CITY OF ALBUQUERQUE

Re: Cantata At The Trails, Pond J Grading Certification
Engineer's Stamp Date 8-09-11 (C09-D001B)

Based upon the information provided in your submittal received 11-29-11, the above referenced plan can not be approved for certification until the following have been addressed.

Sheet No.:  
**C2.04**

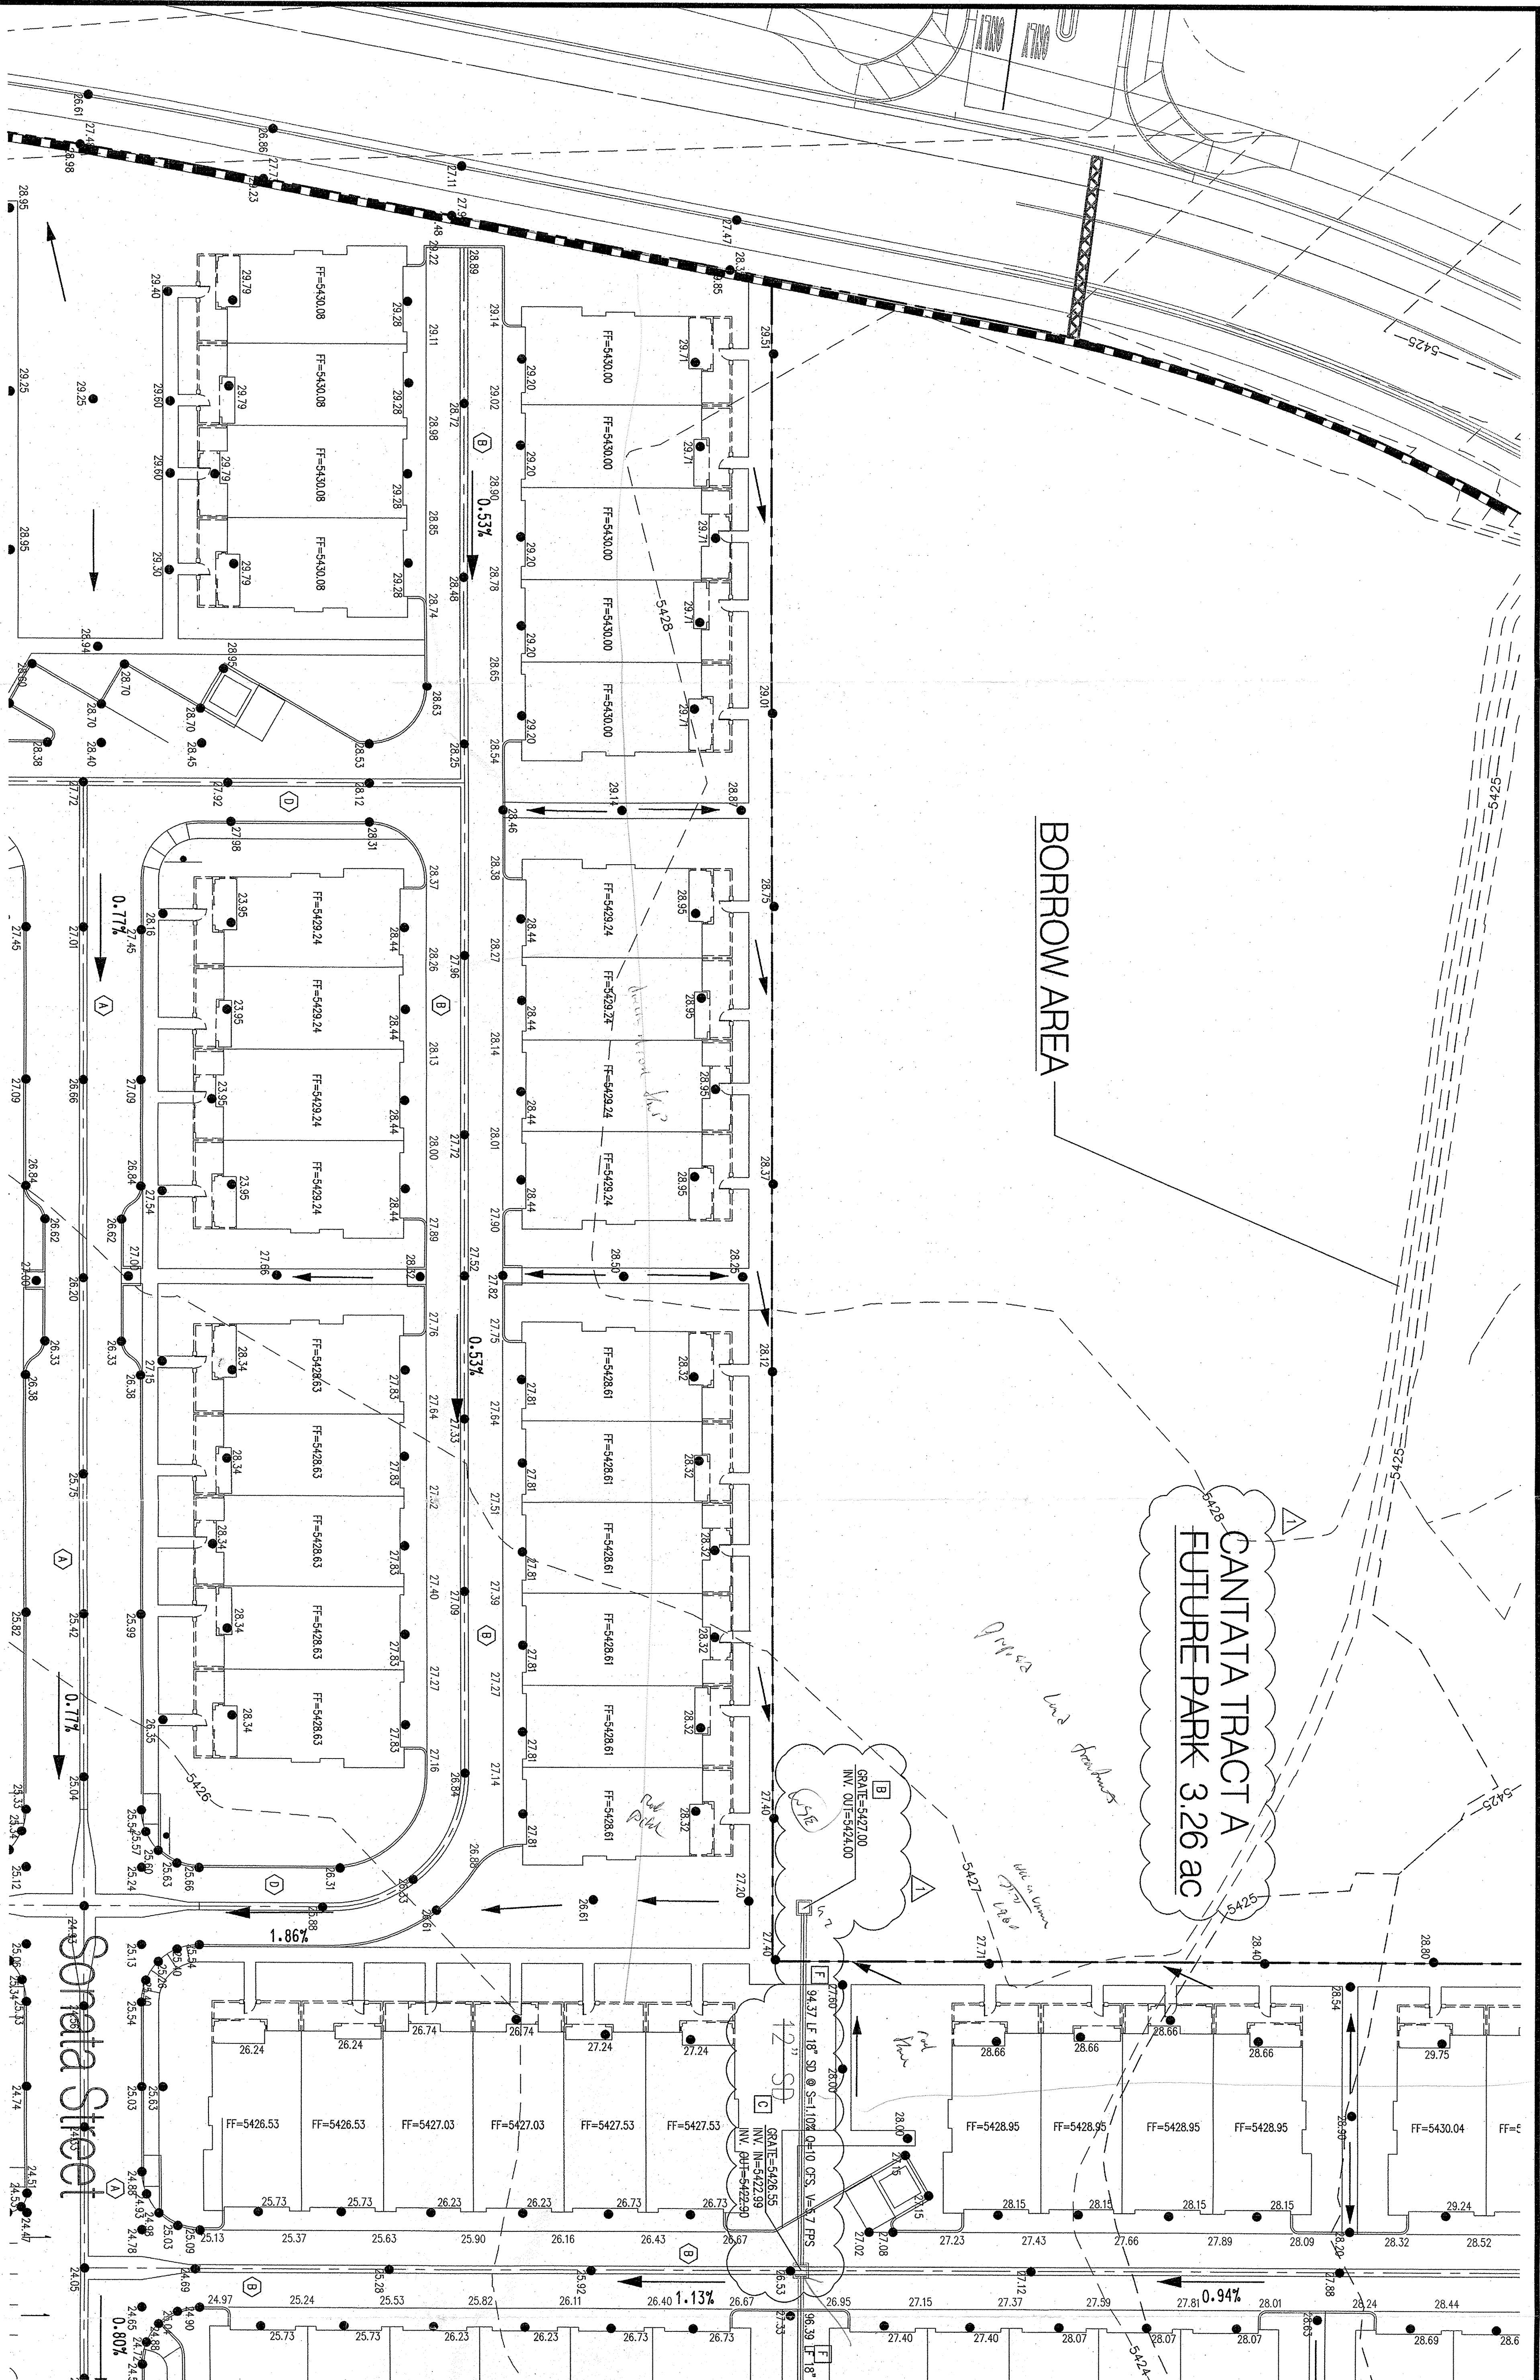
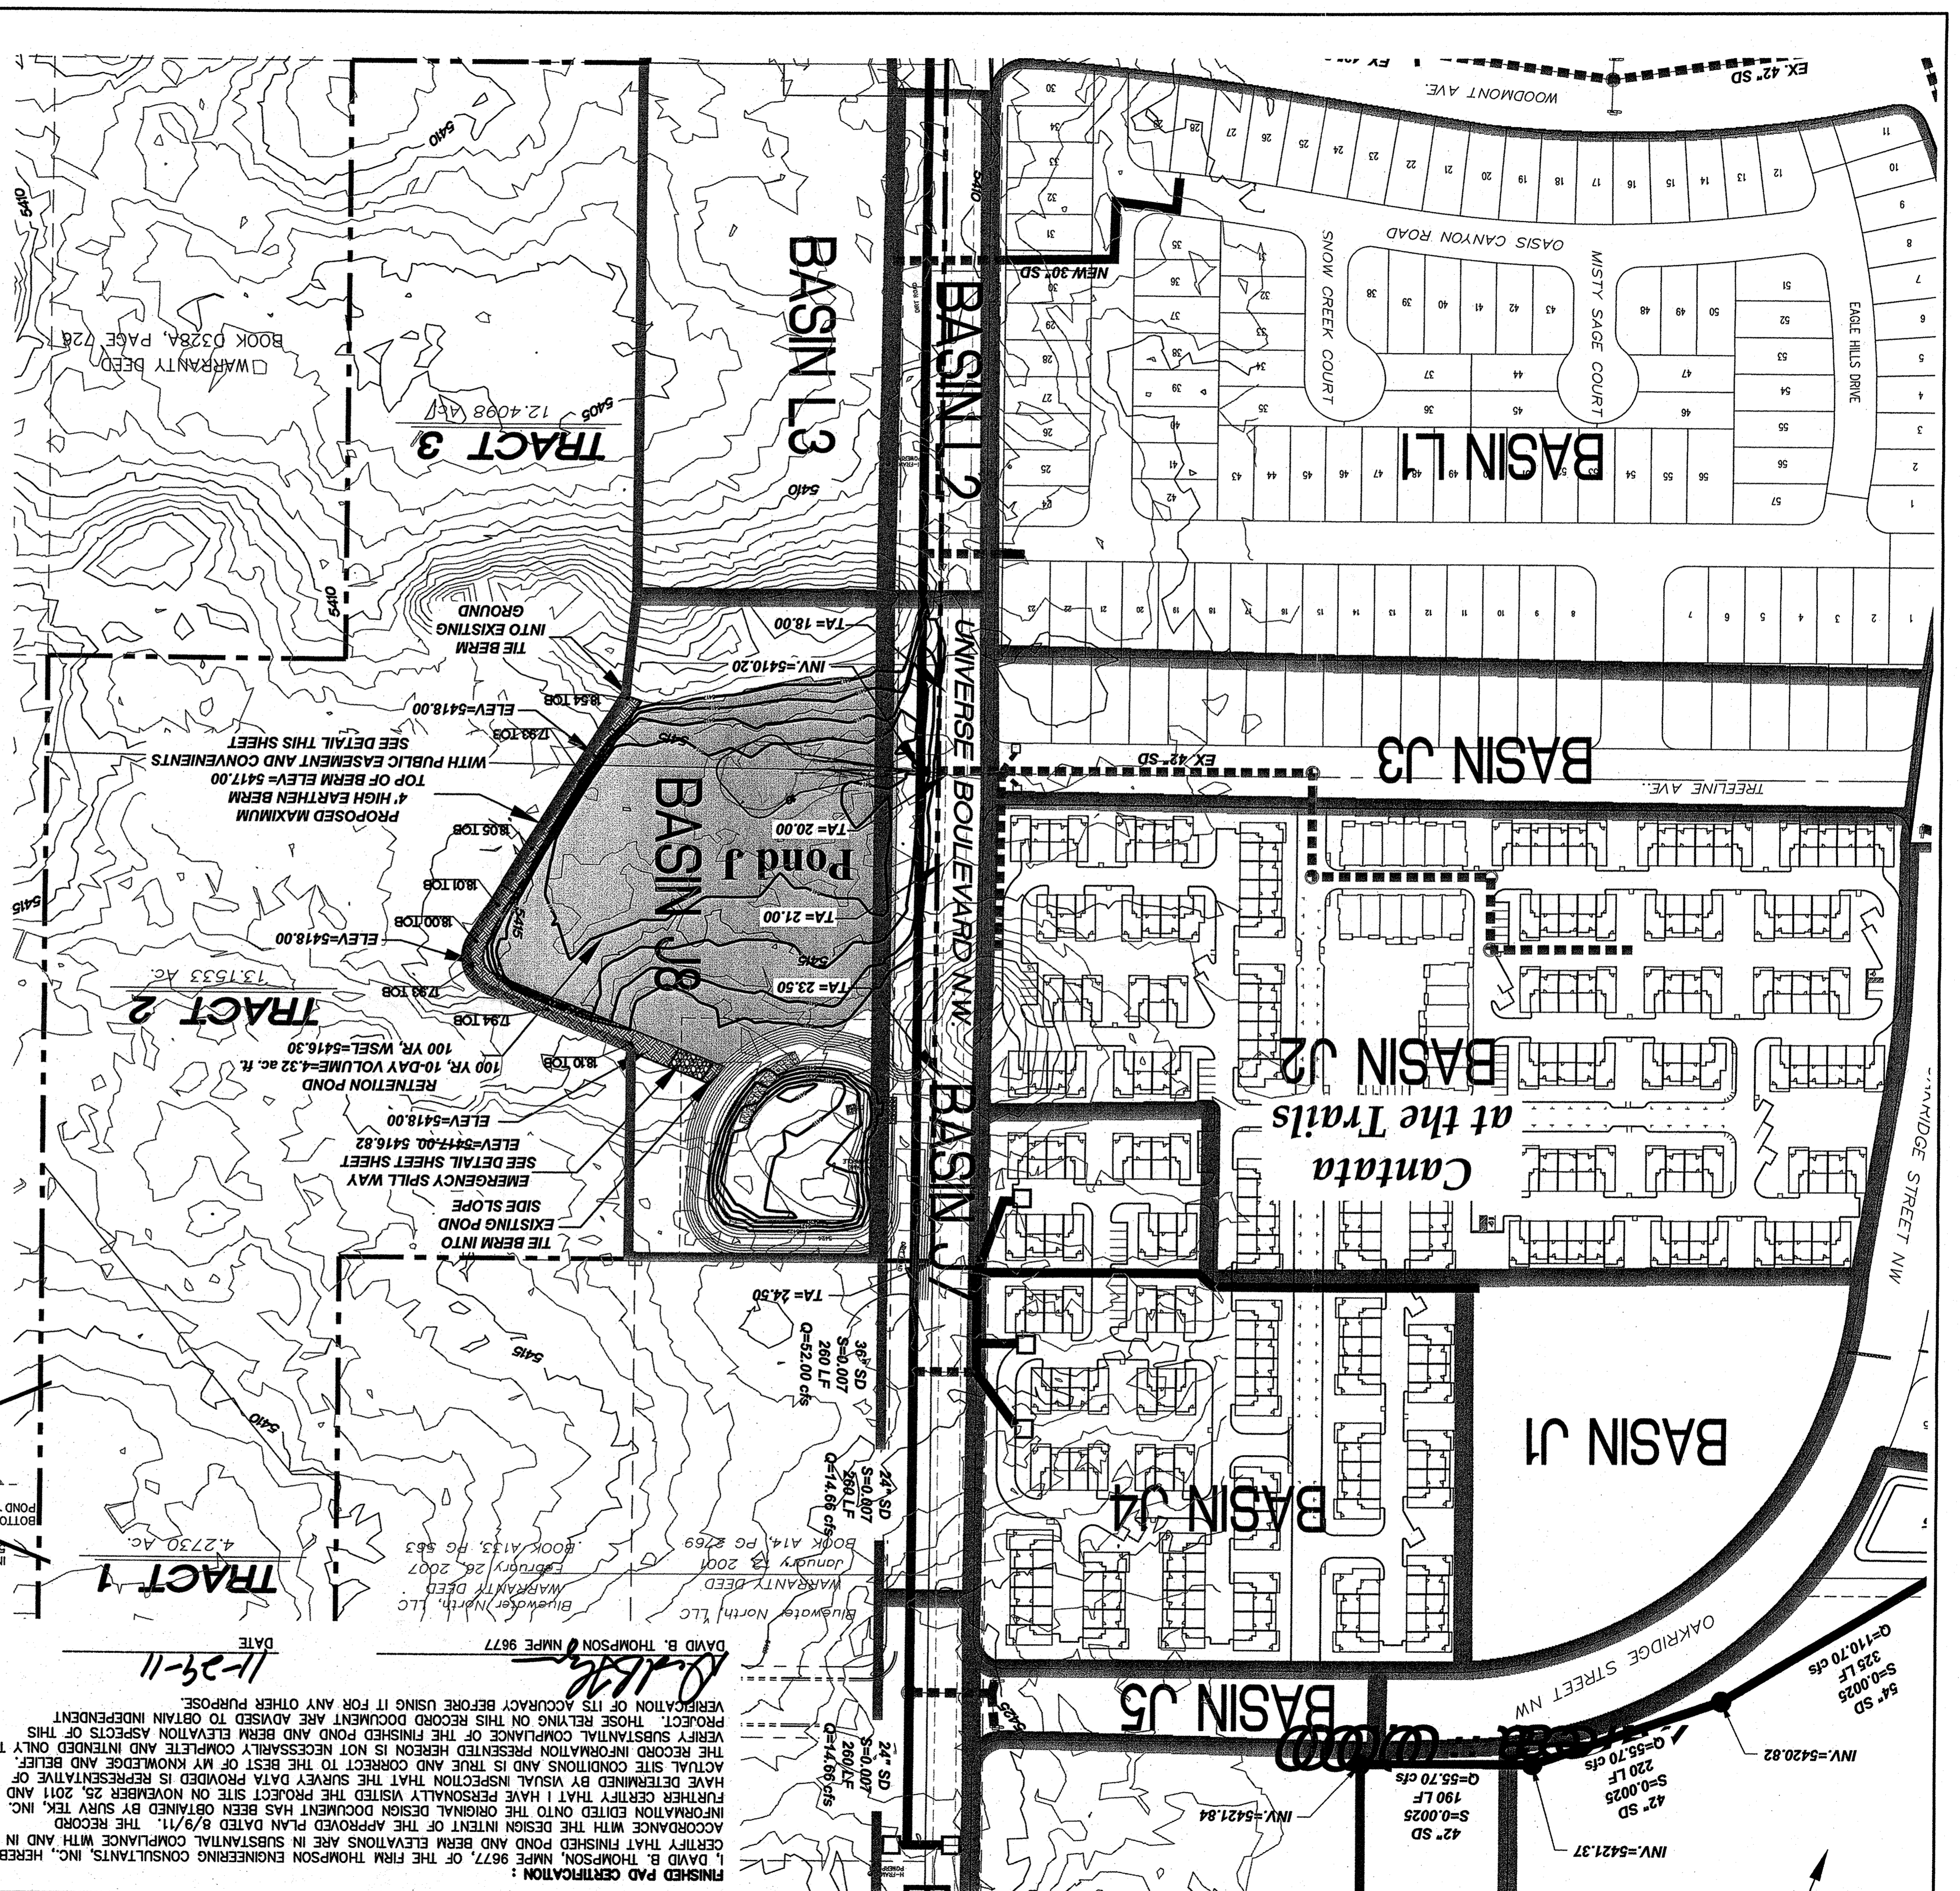
- The existing grades do not reflect the grades on the certification.
- There is approximately an eight foot vertical drop at the 48" storm drain pipe. The grades have to be sloped back or a section pipe may have to be added.
- Please provide a detail with elevations on the emergency spillway. It did not appear to have the wings at the two ends.
